CITY OF ALBUQUERQUE

March 6, 2025

RE: JLM Living – Paseo Multi-family Housing Development
Grading and Drainage Plans
Engineer's Stamp Date: 02/03/2025
Hydrology File: C10D003
Case # HYDR-2025-00020

GRADING & DRAINAGE (1 OF 2)

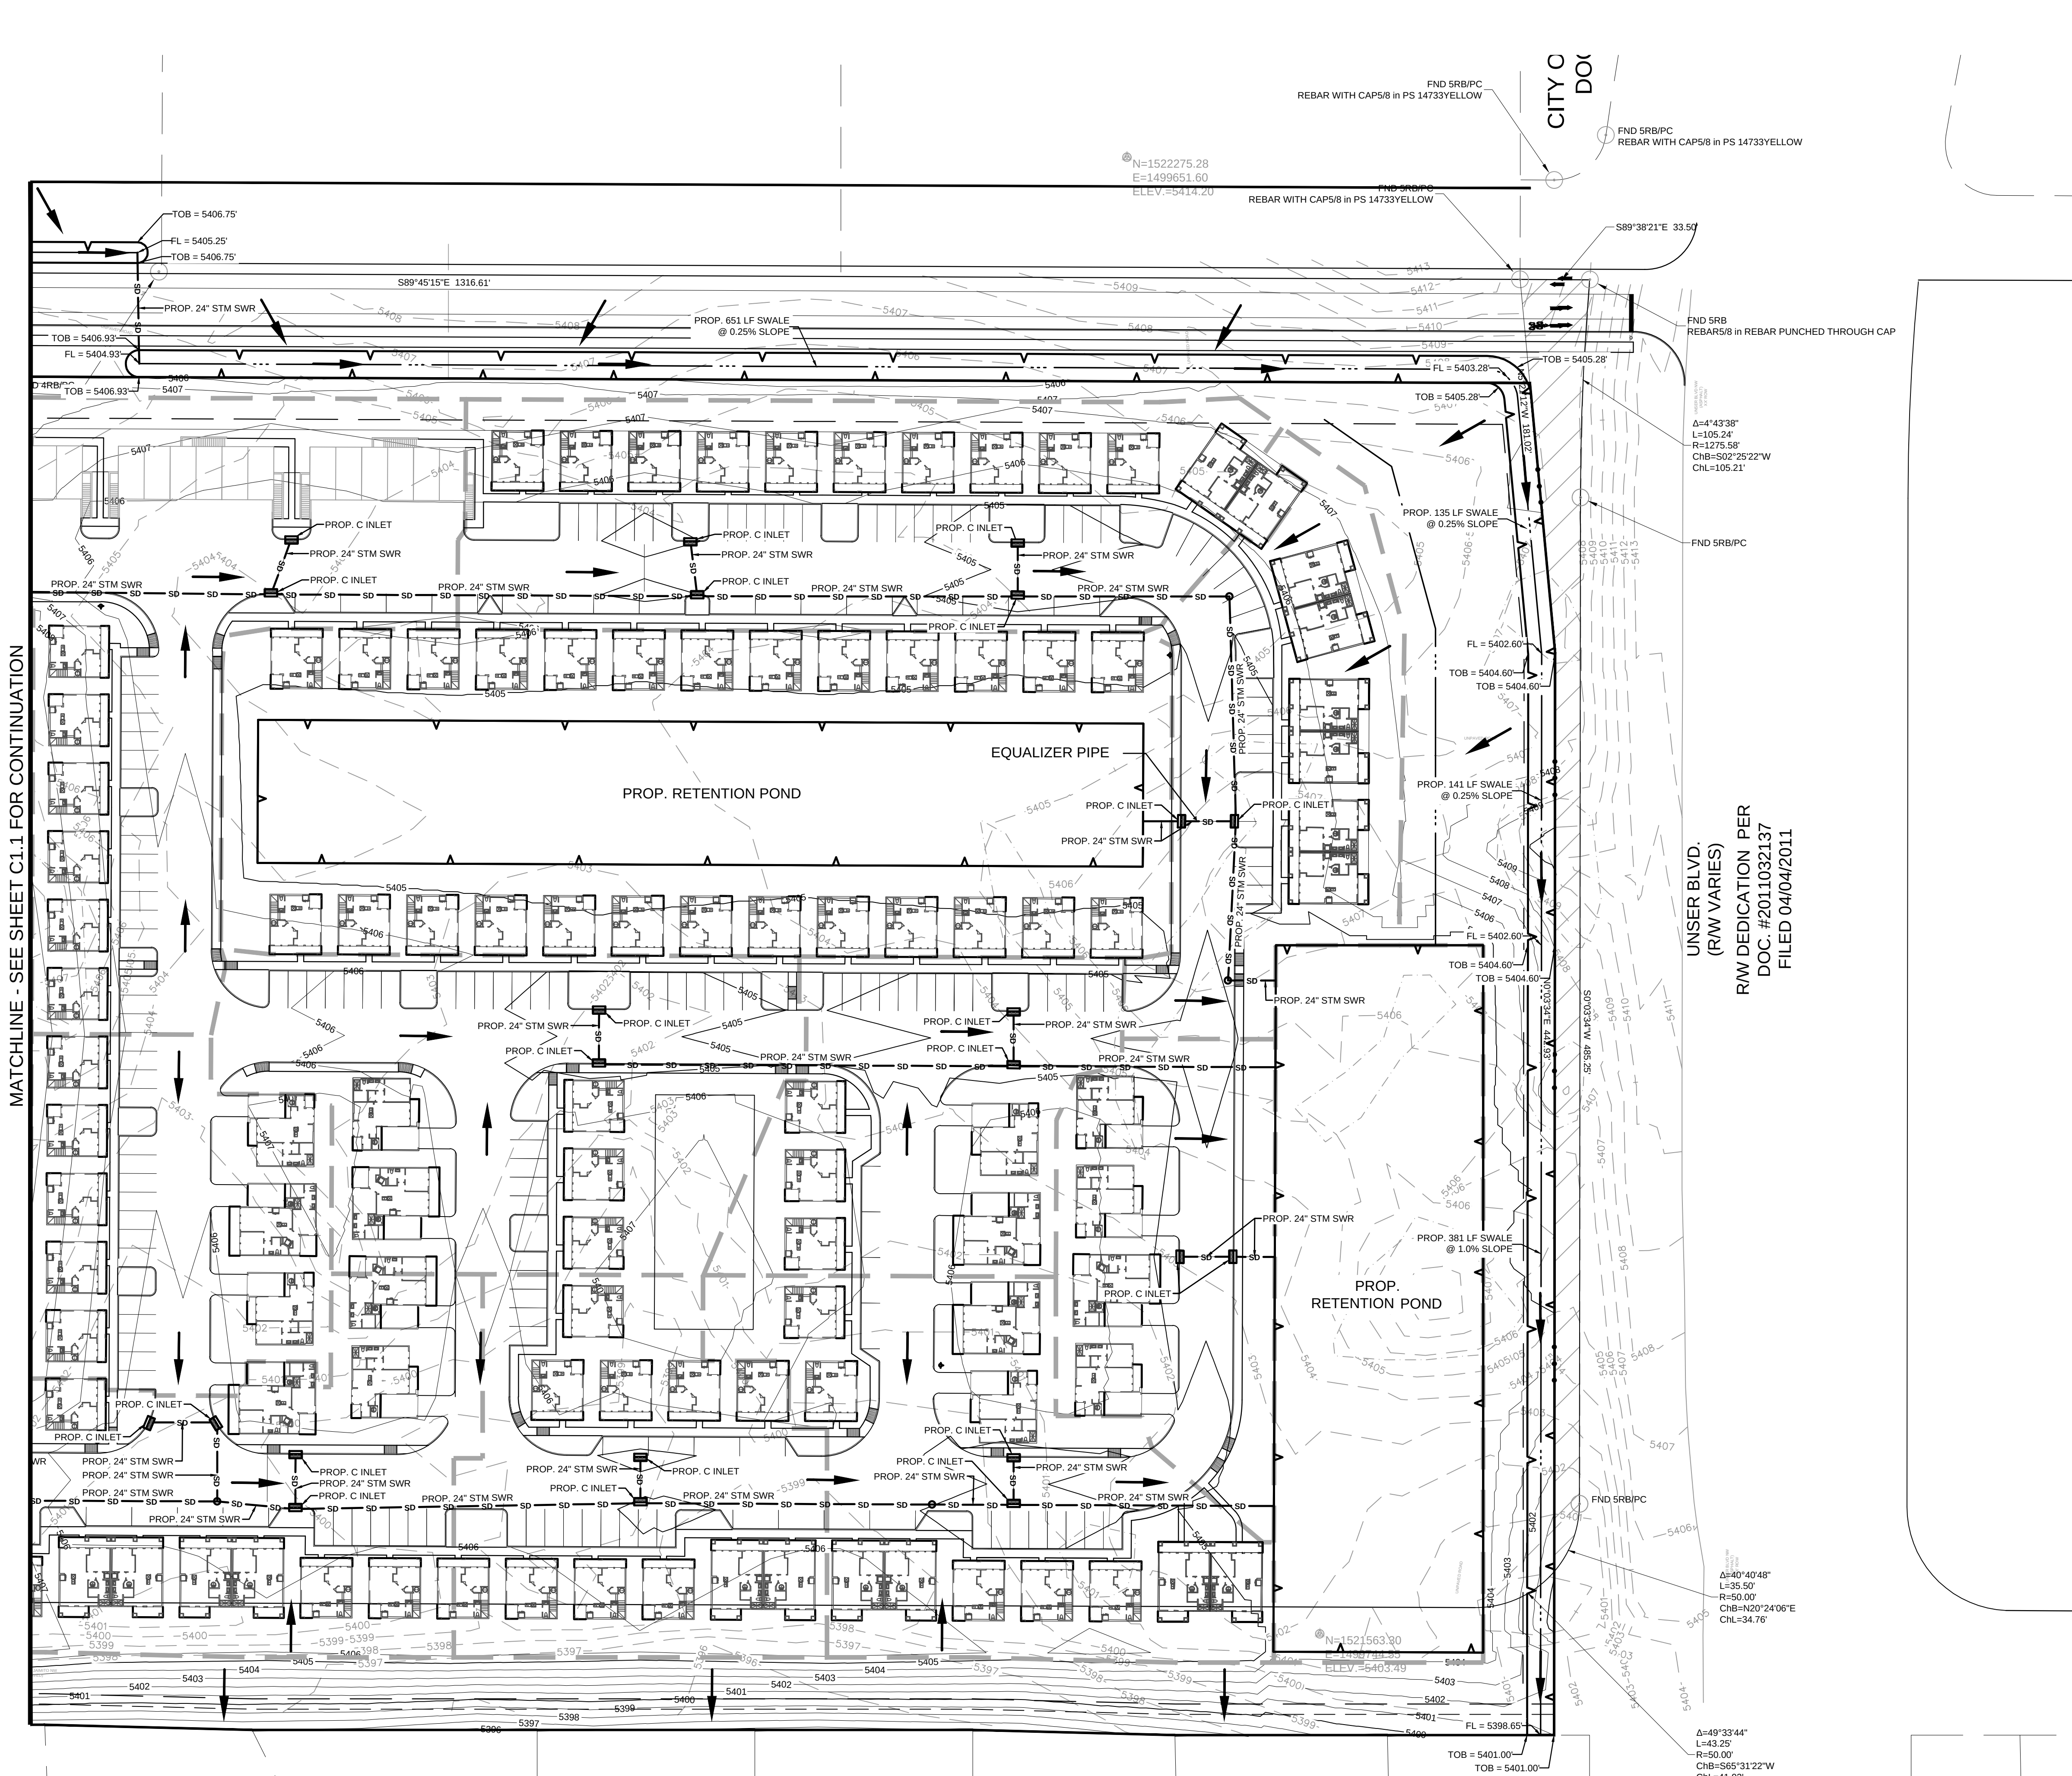
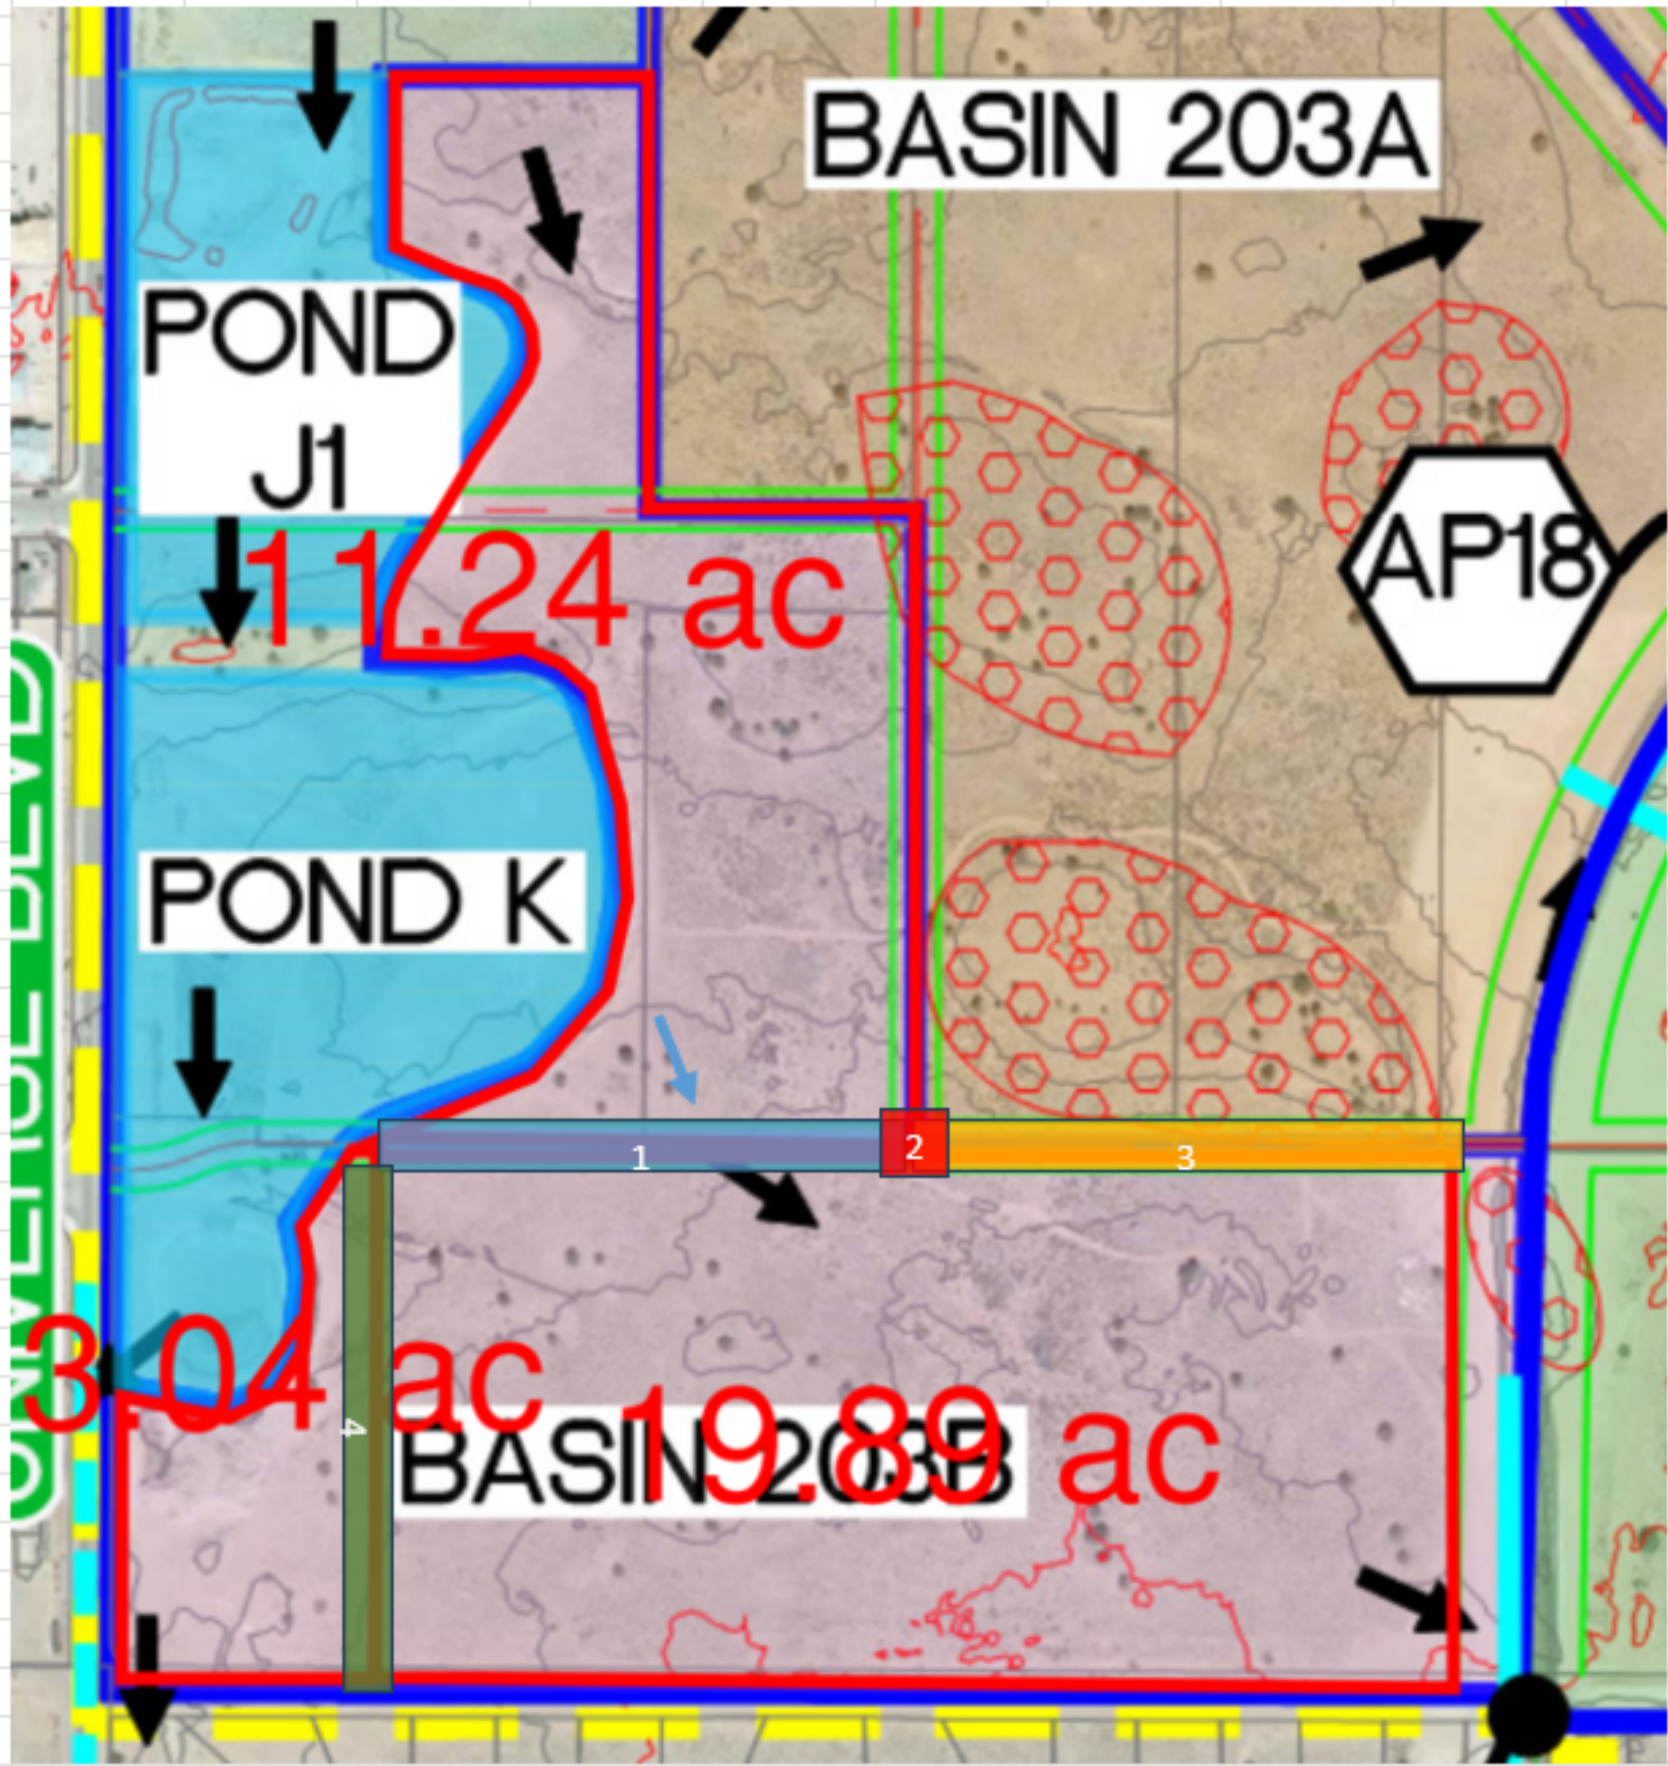
3. Please provide the legal description of the property.
4. Please number the ponds and include a label on each with the SWQV and elevation, the 100-year volume and elevation, the peak 100 year inflow and outflow, the spillway crest elevation, the spillway flow depth, and the dam top elevation.

8. Per DPM Article 6-15(B), please provide the Drainage Maintenance Plan.
9. Per DPM Section 6-11(A)(2), please show the designated overflow point that indicates the flow direction if the pond overtops.

GRADING & DRAINAGE CALCULATIONS (2 OF 2)

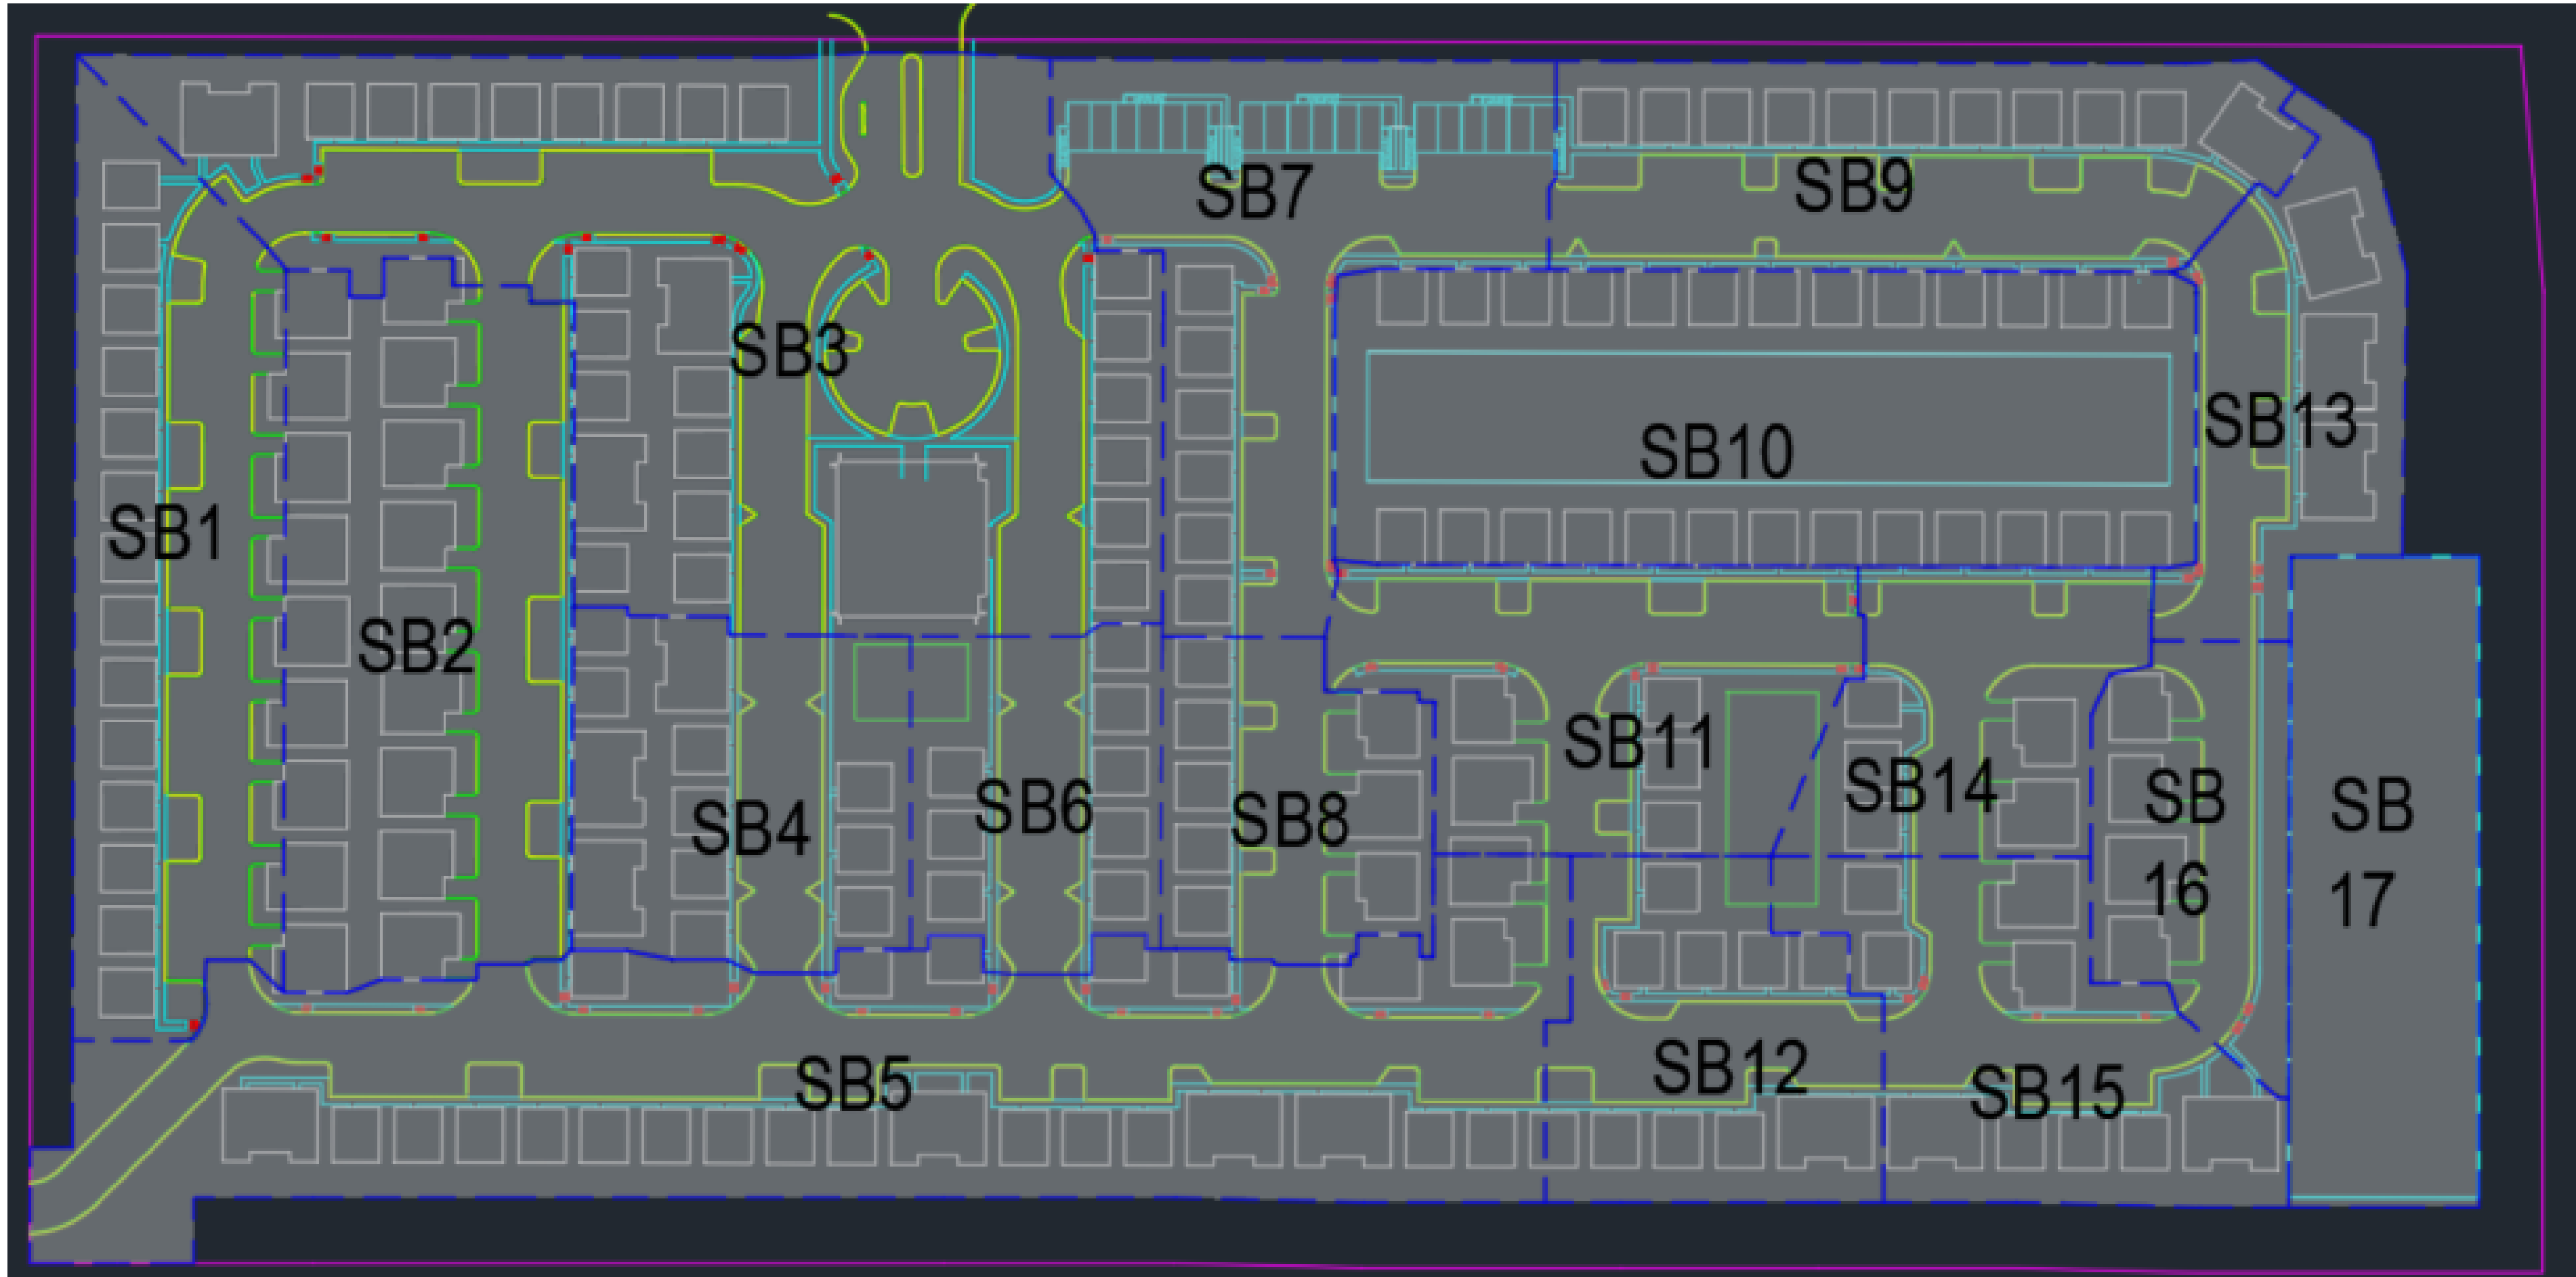
5. Please provide the SWQV calculations for each basin draining to each pond. The stormwater quality ponds need to be sized for the areas draining to them.
